RE: Take 5 Oil Change
6201 Montgomery Blvd. NE
Grading and Drainage Plan
Engineer's Stamp Date: 09/24/2021
Hydrology File: F18D030A

Based upon the information provided in your submittal received November 11, 2021, the Grading & Drainage Plan **is not** approved for Building Permit, SO-19 Permit, and for action by the DRB on Final Plat. The following comments need to be addressed for approval of the above referenced project:

SHEET C300

C 300

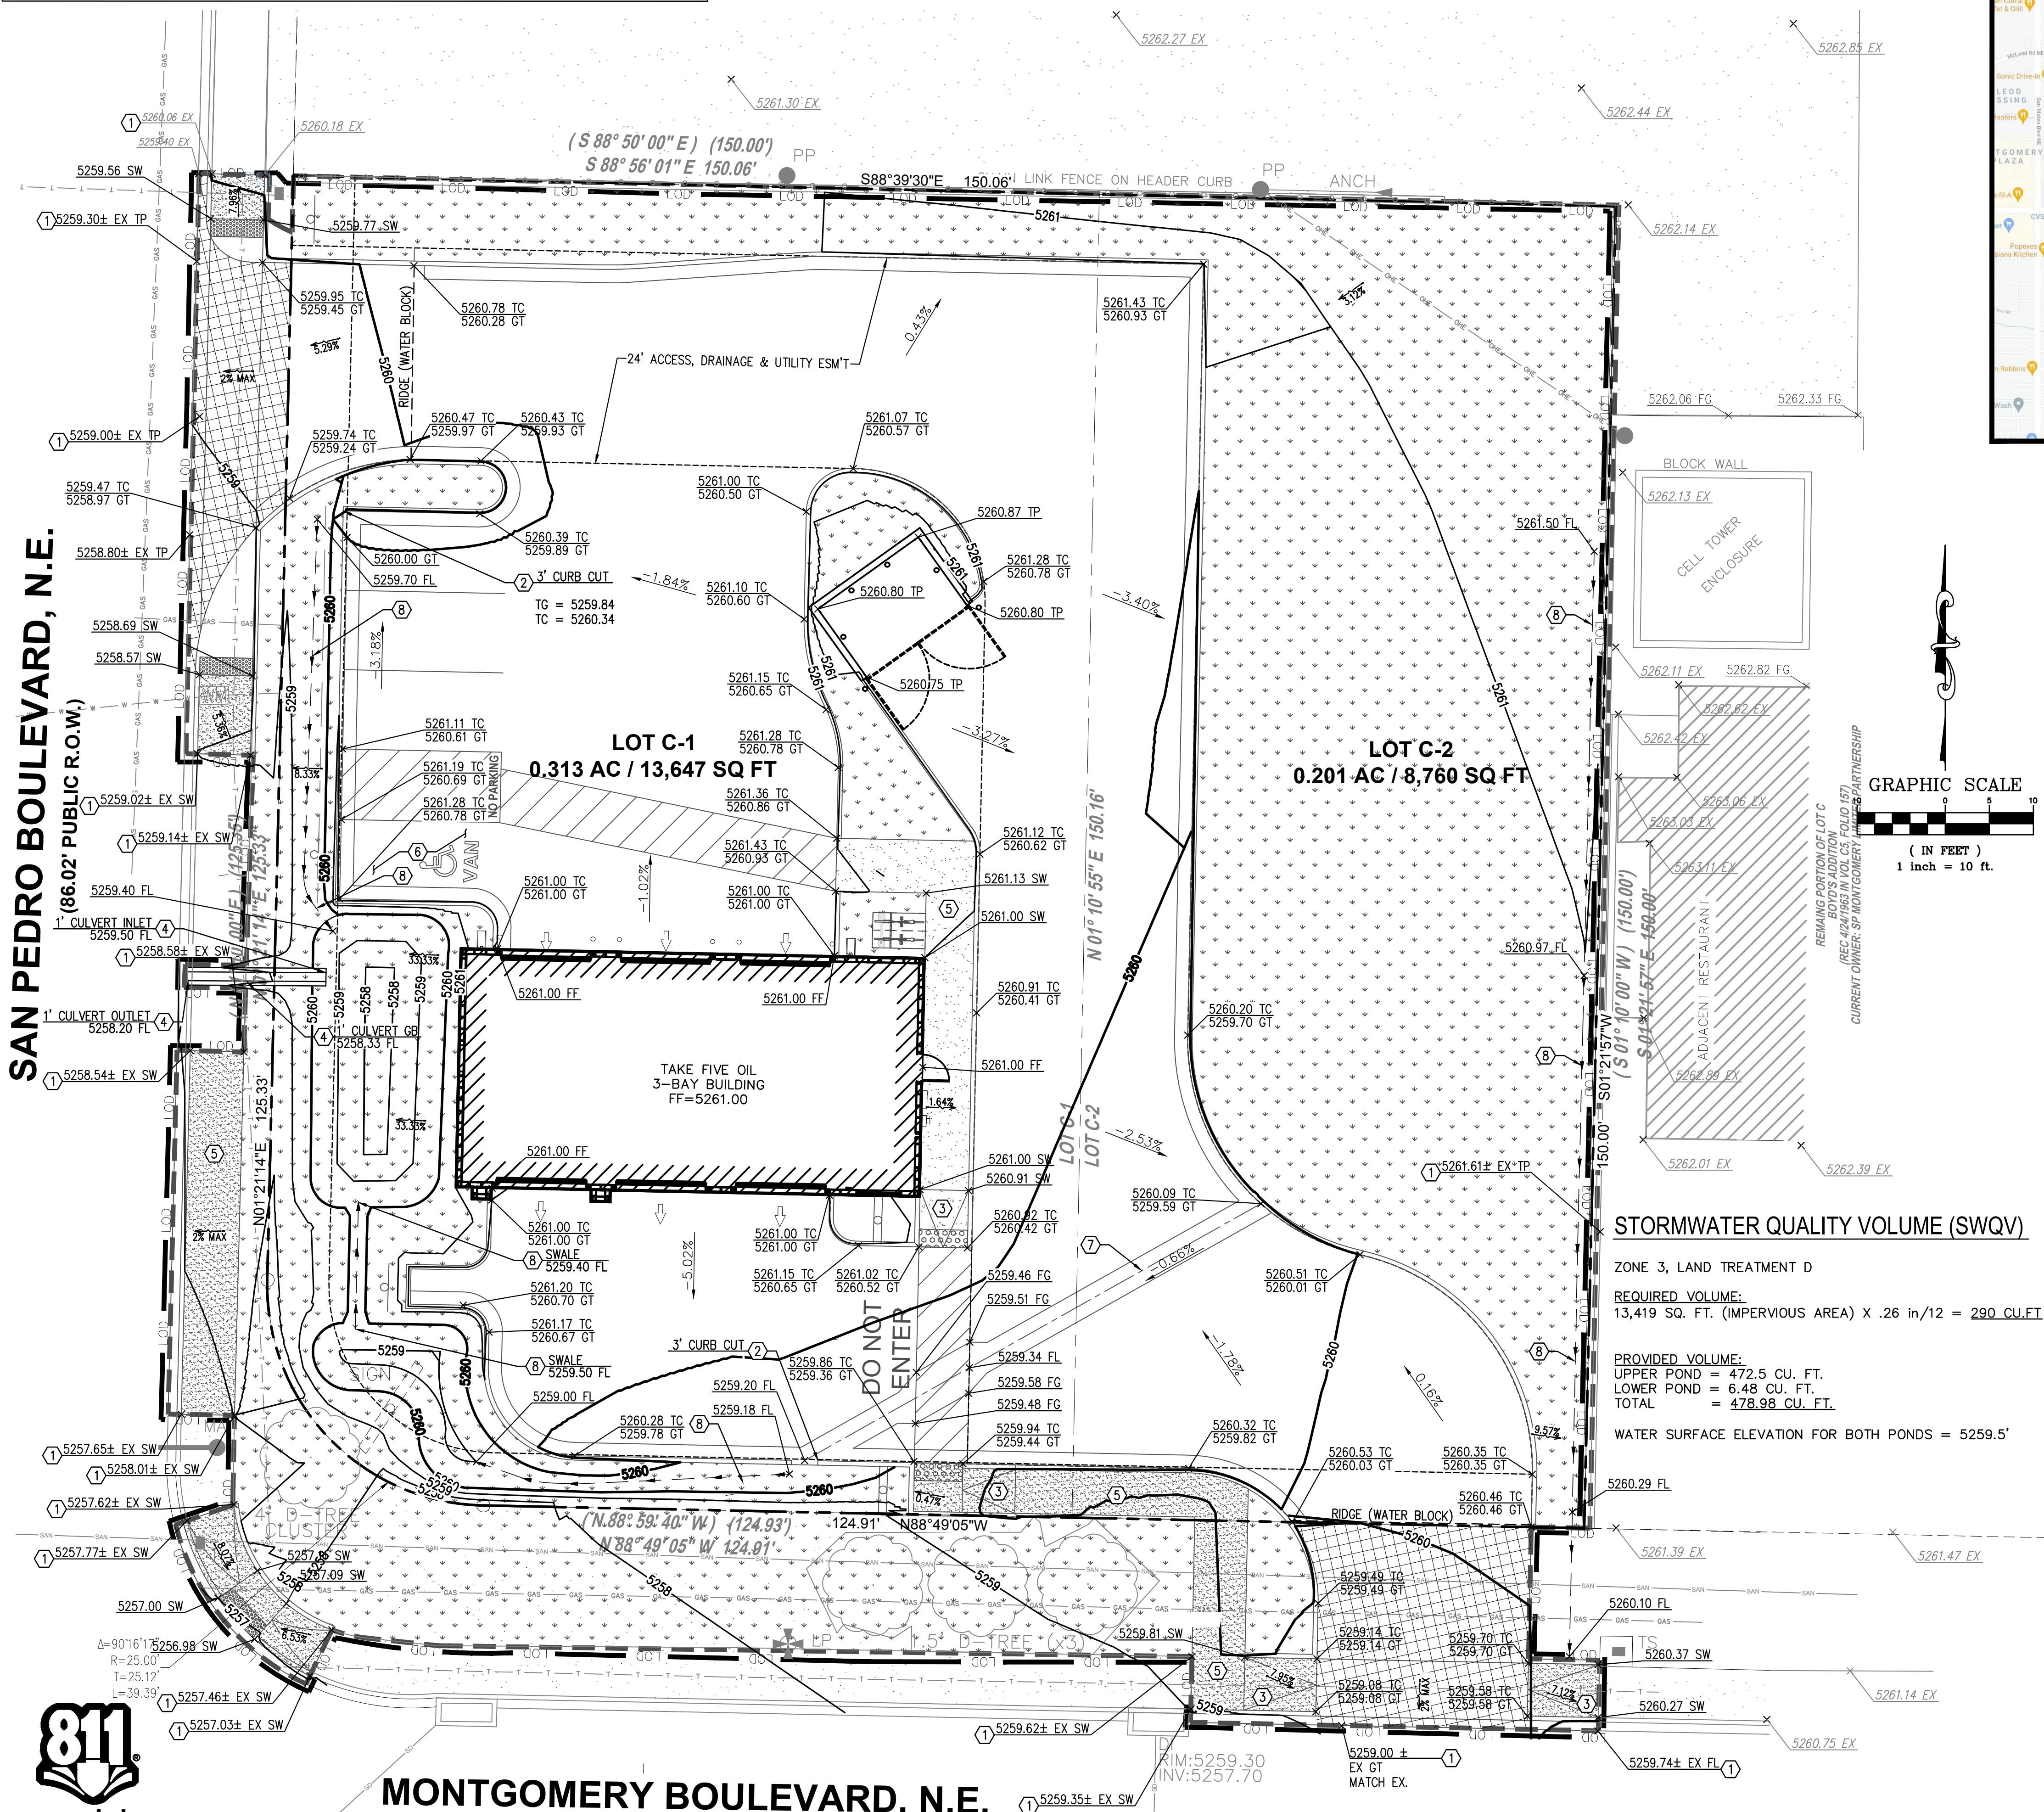
1. Please include the site map on this sheet.
2. Please provide all calculations per DPM chapter 6 to show required water quality volume, applicable land treatments, and zone as noted within the DPM.
3. The G&D must be a standalone plan and include all benchmark information and datum. Please reference this information.

6. Account for adjacent Lot 2 and design such that flow is conveyed to the pond/Water Quality Pond.

7. A waterblock, 0.87' high, per COA Paving Detail No. 2426, is required at the driveway entrances.

- a.
9. Please note historical conditions and ensure any predevelopment flows are maintained from adjacent lot. If there is cross lot drainage, please note document number for the easement. Develop cross lot drainage easement for proposed lots as well.
10. Clearly show the lot line split between lot 1 and lot 2 as proposed.
11. Provide spot elevations from survey and include spots around the site to show how it ties into existing grades for adjacent sites. Include how drainage works with the overall shopping center and any flow that drains across lots must be accounted for. (e.g. if this site accepts drainage from other sites, please note, if this site drains to other sites, please note).

12. Please note any easements (proposed and existing).

13. Please include attached SO-19 notes.
